**Drawing showing bar space wheelchair accessible**

*Jeanie Bourke*  
*Code Enforcement Officer/Plan Reviewer*  
*Team Leader*

5 REACH RANGE ADA/ TABLE COUNTER
1/4" = 1'-0"

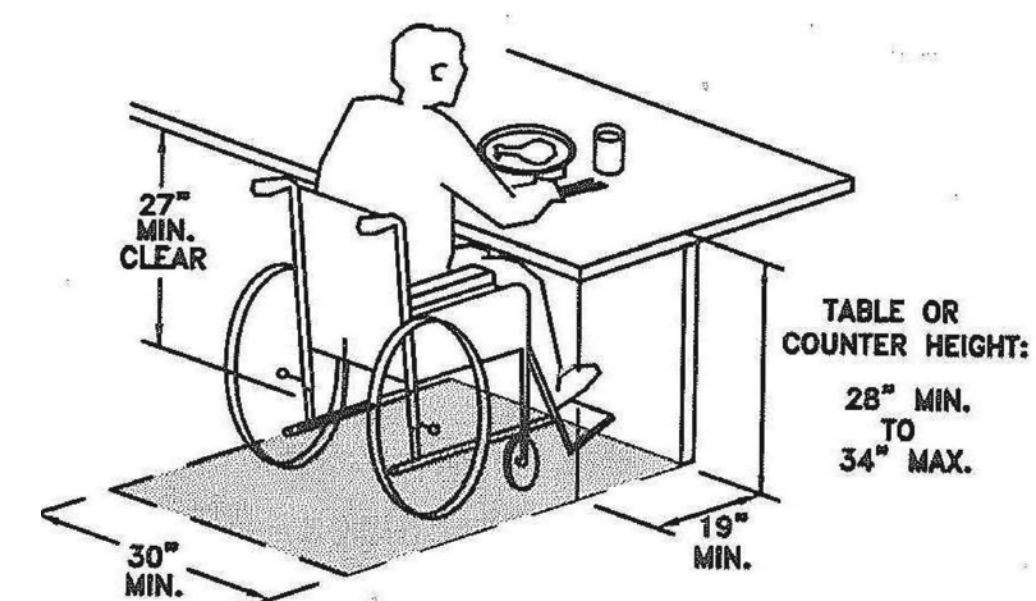
In regards to the 5% ADA seating requirement, the one space at the window counter height of 34" is sufficient for the bar and counter area.

The 5% seating is required to be dispersed, so in keeping with the approved plans, the counter area complies with this.

1 Callout of PROPOSED FLOOR PLAN
1/2" = 1'-0"

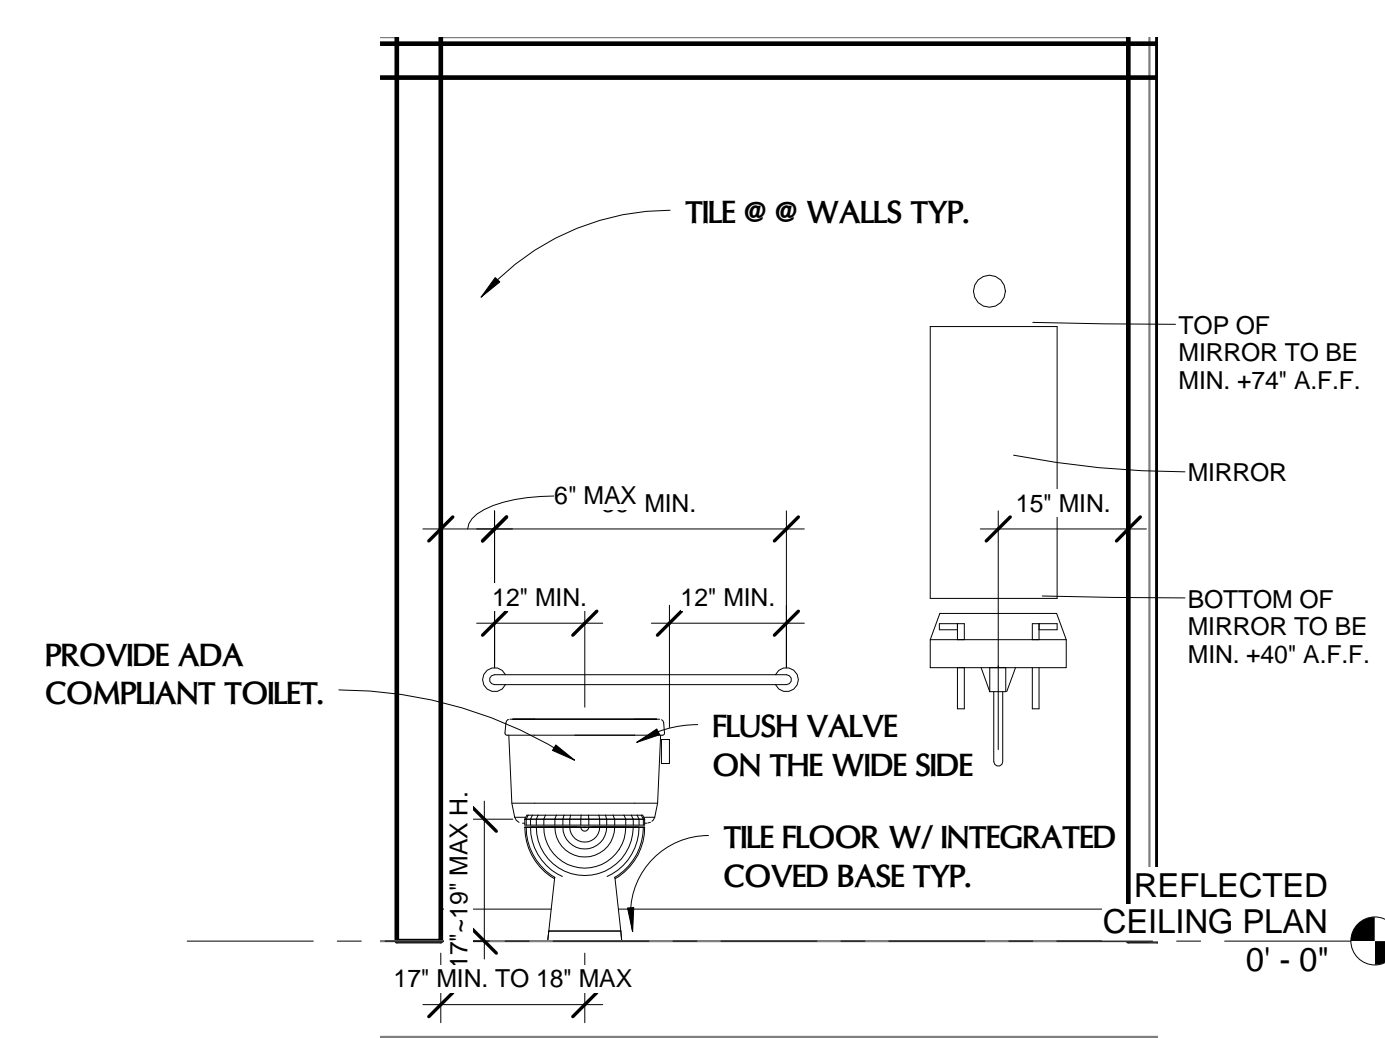
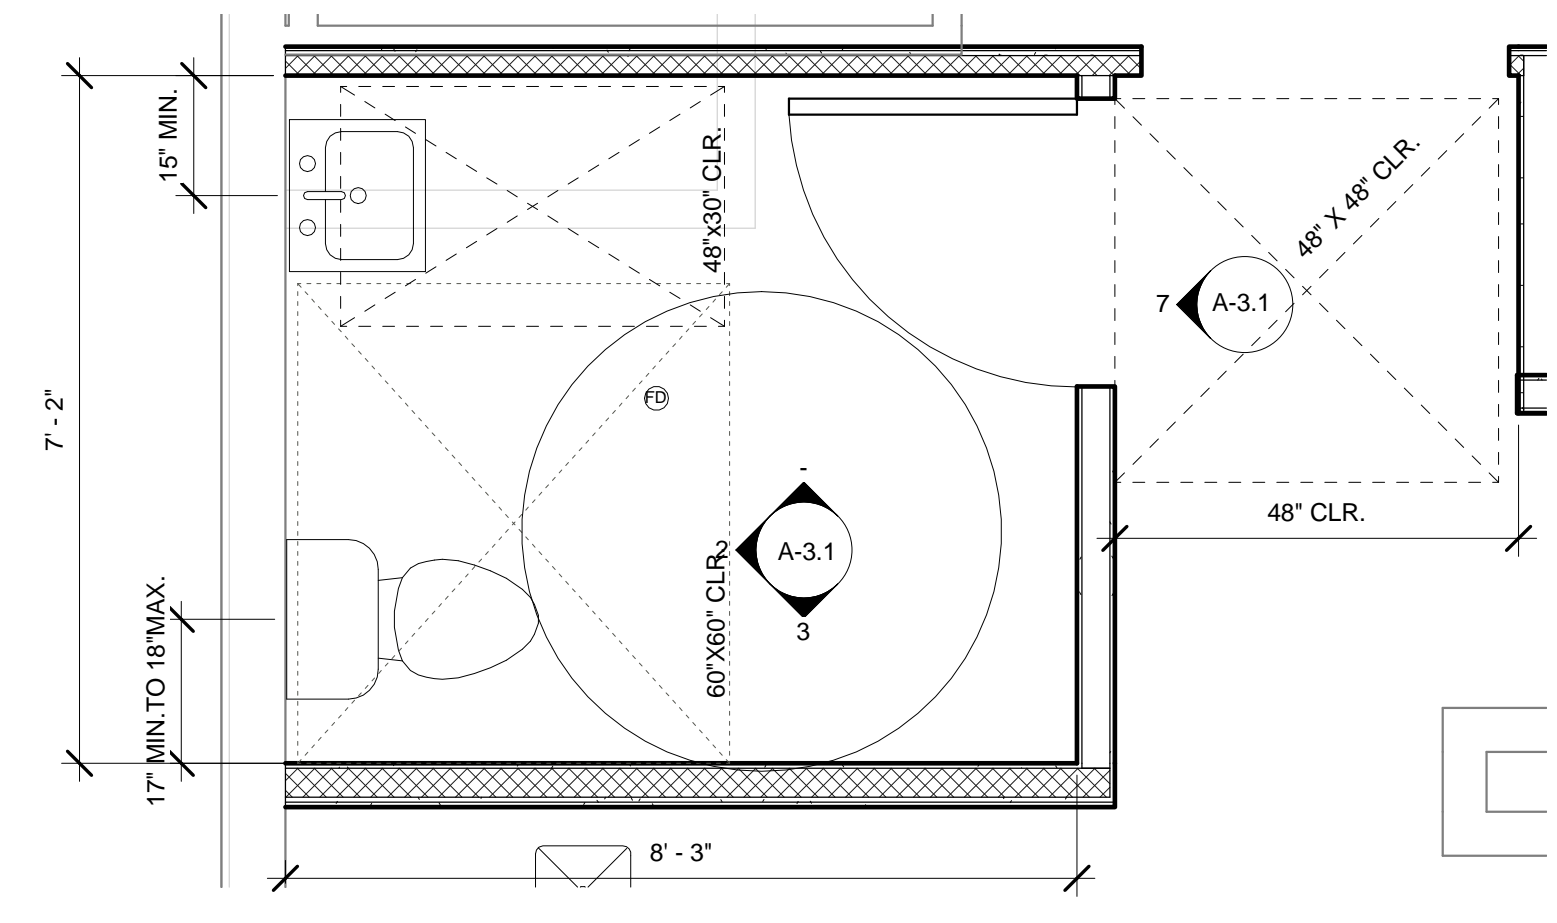
In regards to the addition of a urinal in the ADA bathroom, this looks to meet the fixture clearance requirements and the door clearance, however without an 18" dimension line at the latch side of the pull door, or the dashed line door clearance I cannot be certain.

Yes it can be installed, it needs to meet the dimensional requirements for an ADA urinal at the specific height range and center clearance to walls.
